CITY OF ALBUQUERQUE

January 24, 2022

Re: Pima Medical Institute New Class Room Building
4400 Culter Ave NE
Traffic Circulation Layout
Architect's Stamp 01-03-2022 (H17-D054B)

2 H.C. Ramp Detail
Scale: Not To Scale (Isometric) FOR INFORMATION ONLY

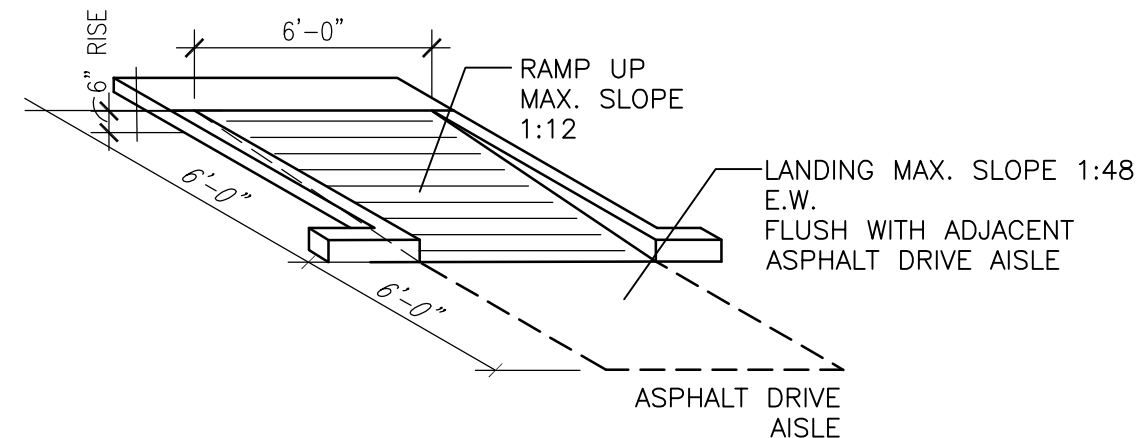
- Verify both existing ramp, at entrance, are update/current ADA . Since you are touching the ramps by modifying the detectable warning surfaces and the existing patterned concrete, and the transitions wings that are not orthogonal to the traffic flow (this makes them non Ada compliant). You will need to replace the ramps.
- The western leg of entrance ramp is in conflict with the existing sidewalk connection onto site since the transition/wing are not orthogonal to the traffic flow. Please replace.
- **Keyed Note 38:** Calls out truncated domes but pattern concrete existing on ramp legs. Will proposed domes complicated the existing patterns which makes it difficult to traverse across these patterns and the addition of detectable warning surfaces.
- **You will need a Sidewalk Easement for existing sidewalk located outside of public ROW. See attachment for the forms.**

- You will need more details on the handrailing including the barrier and edge protection at bottom of railing.
- The landing will need to be 60x60 and label slope 1:48max.
- The run slope will need to read 1:20max.
- How will you provide a update/current ADA ramp adjacent to bike racks when a 6 ft pedestrian pathway will be needed. I suggest you replace the existing ramp for a current ADA accessible design and provide from that point to the entrance 6 ft width of pathway (CLEAR from ramp to entrance).
